**Application Reference: 2025/0052**

**Site Address:** 30 Wainwright Avenue, Wombwell, Barnsley, S73 8LS2

This application seeks full planning permission for a 2 storey side and rear extensions to 2 storey semi-detached dwelling.

Drawing Title
PROPOSED PLANS

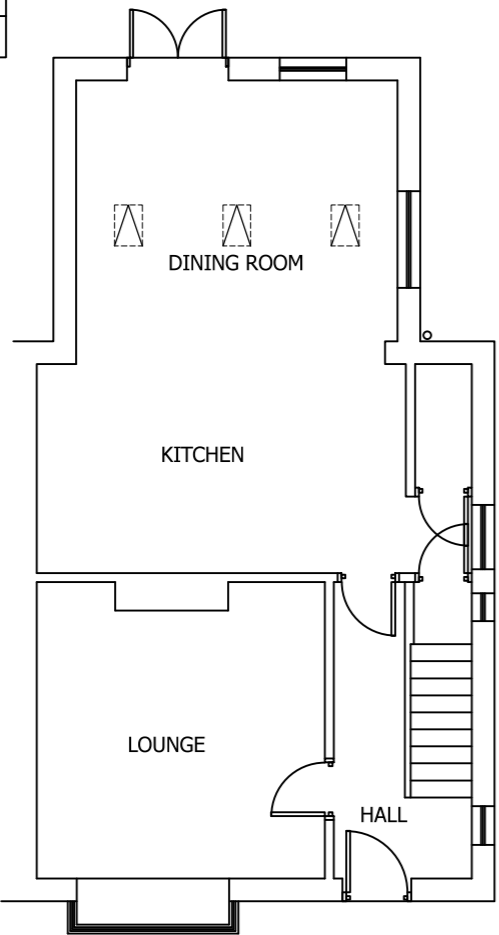
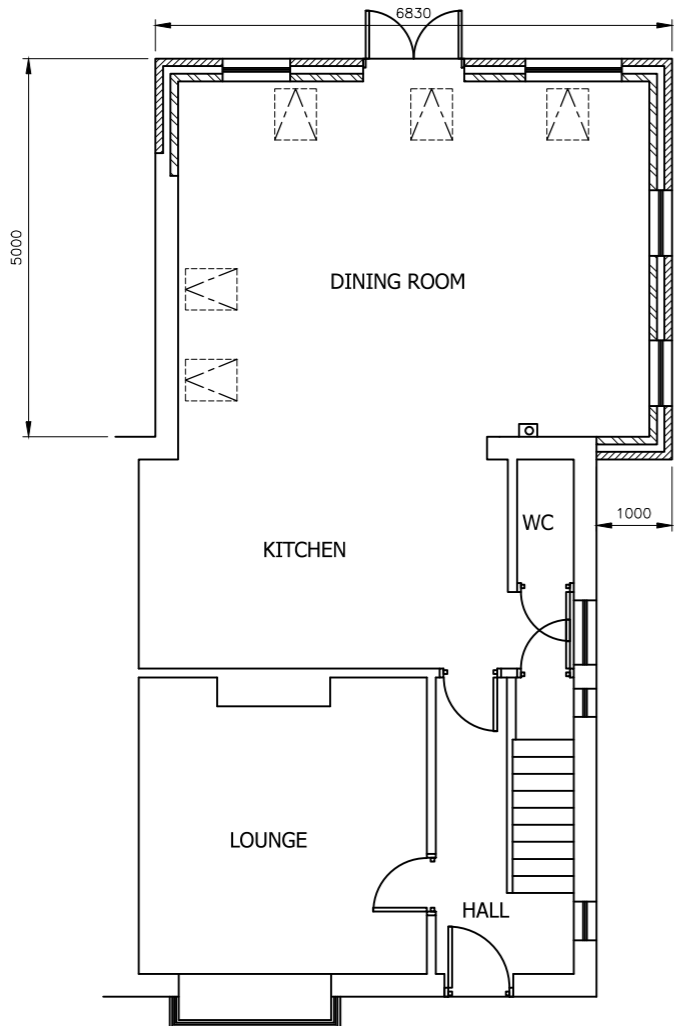
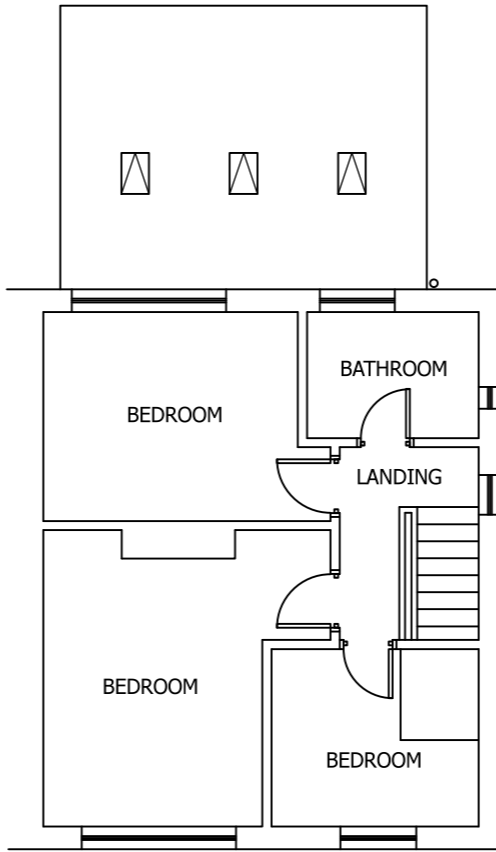
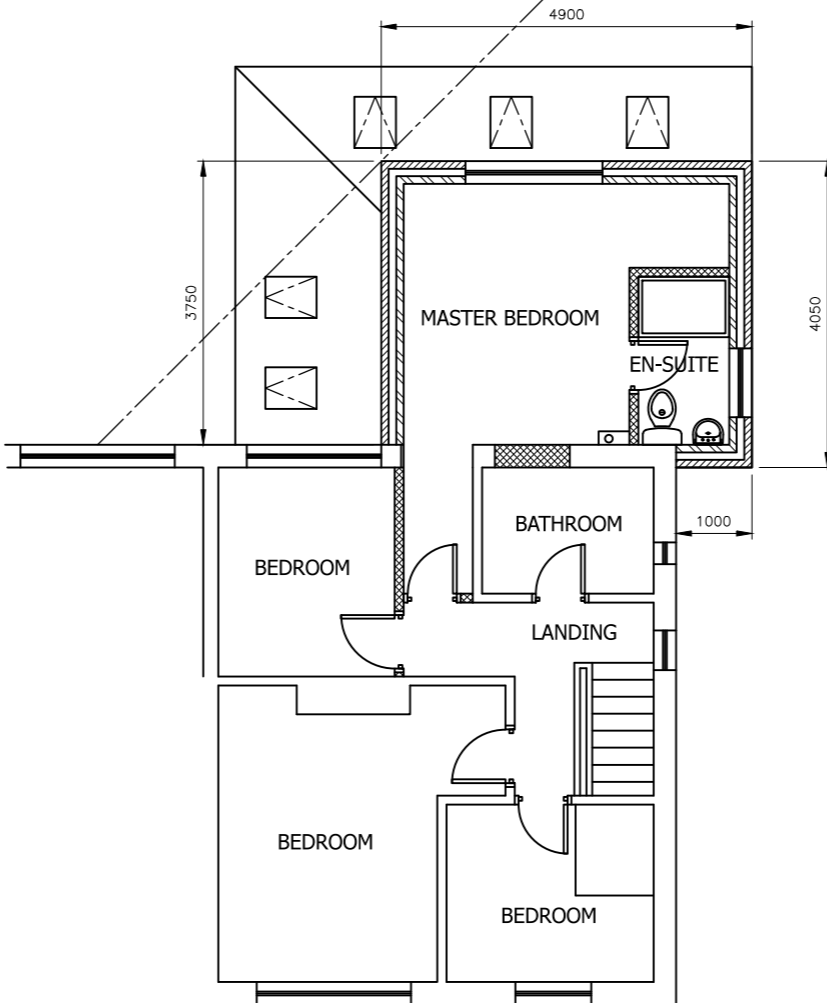
The proposal is to extend (or replace) the existing rear extension, at a ground floor level by approximately 1.25m to a maximum rear projection of 5m whilst the extension would also be extended on the side elevation by approximately 1.88m to maximum width of 6.83m. With the existing extension not projecting beyond the side elevation, the total side projection of the proposed extension would be 1m with a slightly longer length of 5.3m, creating in essence a very small wrap around extension.

The second aspect of the proposal is the addition of a first floor extension above the proposed extended ground floor extension. This first floor addition would be of a smaller scale with a side projection of approximately 1m, and an overall width of 4.9m. The side aspect of the extension would have an approximate length of 4.05m but the rear projection from the original rear wall of the dwelling would be approximately 3.75m

To minimise its impact, the ground floor aspect of the rear extension is only being extended 1.25m further into the garden and features no side windows on the ground or first floor side elevations facing the attached neighbour of No.32. The first story aspect of the proposal has also been set back from the boundary with No.32 by approx. 2.2m, this prevents the 45 degree rule being breached by first storey extension. In contrast the existing ground floor extension already breaches the 45 degree rule, and the proposed increased projection whilst continuing this breach would not have an extensive detrimental effect upon the amenity of No 32. Mitigation in favour of the proposal would arise from the relatively long garden of No.32, and despite a large tree at the bottom of their garden, the rear boundary of many dwellings adjacent to the application dwelling overlook a broadly open area of land, providing a sense of openness and improved light penetration from the west. Balancing these factors, the impact on the amenity of No.32 would be considered as Moderate.

Drawing Title  
**PROPOSED ELEVATIONS**

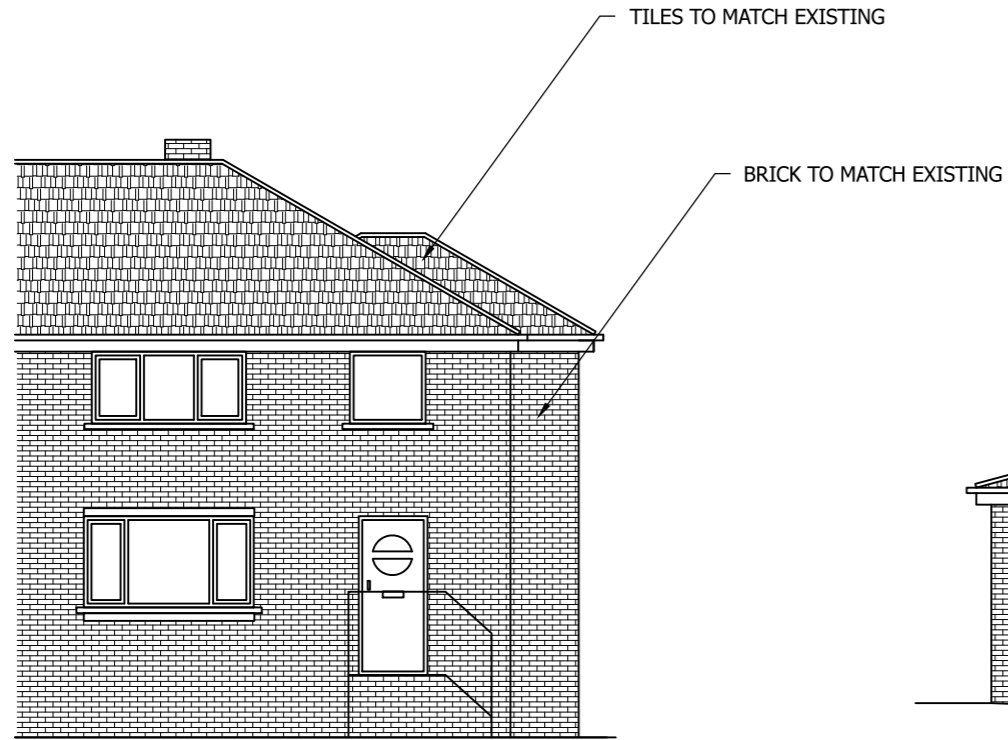
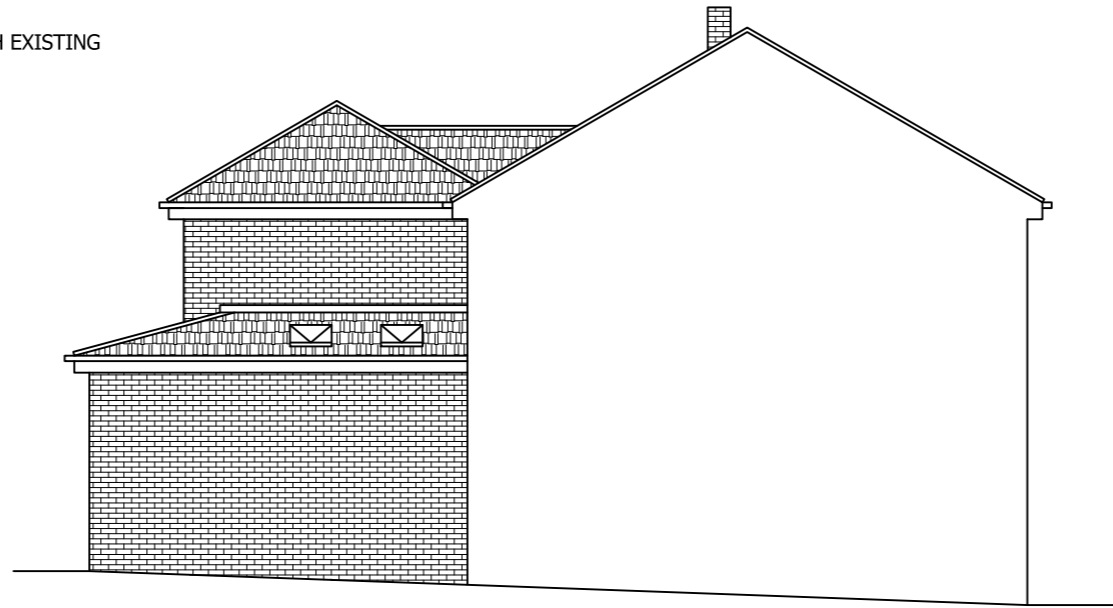
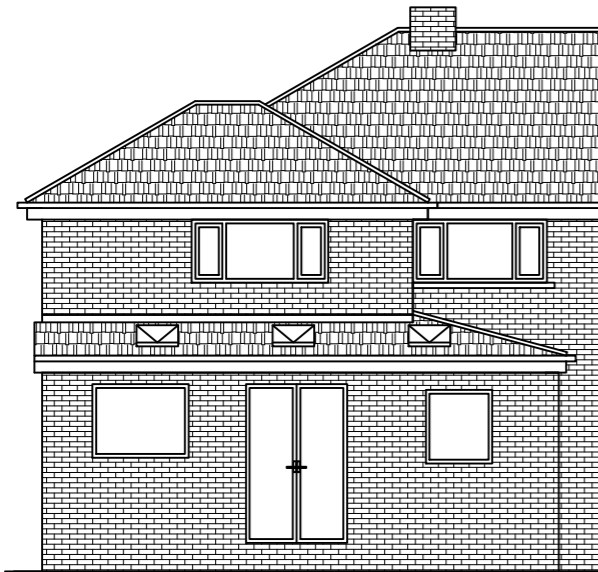
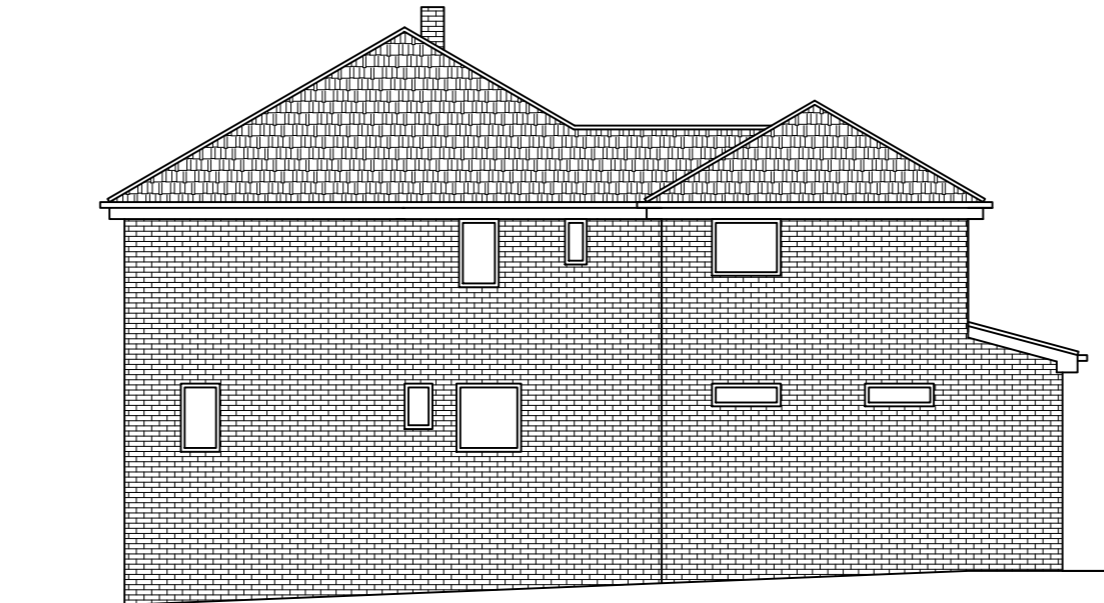
The height levels for the proposed two storey extension, measure on the side elevation at the join with the original dwelling are approximately 4.8m for the eaves, matching the original dwelling's eaves, and a maximum height of 6.37m, lower than the original dwelling's roof. For the single storey aspect, measured at the side elevation join with the two storey extension, are approximately 2.6m for the eaves, and 3.29m for the roof height.

Through the use of matching materials and similar roof styles, there has been an attempt to harmonise the proposed works with the existing dwelling and ground floor extension. The design overall is acceptable but the key front elevation features the most successful integration with the existing dwelling and also meets local policy guidance with the inclusion of a step down in roof level and set back from the front elevation. The side and rear elevations are equally acceptable have been designed to complement the existing building but the different roof levels do have an impact. In consideration of the whole design, the proposal would be considered to have a limited effect on design.

The overall proposal when including the size of the original extension for which the proposal extends on two elevations and upwards, the size is reasonably large. However, as mentioned above, the design of the proposal especially in regard to the street scene is less impactful. Following completion of the proposed works, it would be undeniable that the character of the dwelling had not been altered but not to a noticeably detrimental level. It would therefore be considered that the impact on the character of the dwelling, and the dwelling's position within the street scene would be limited.
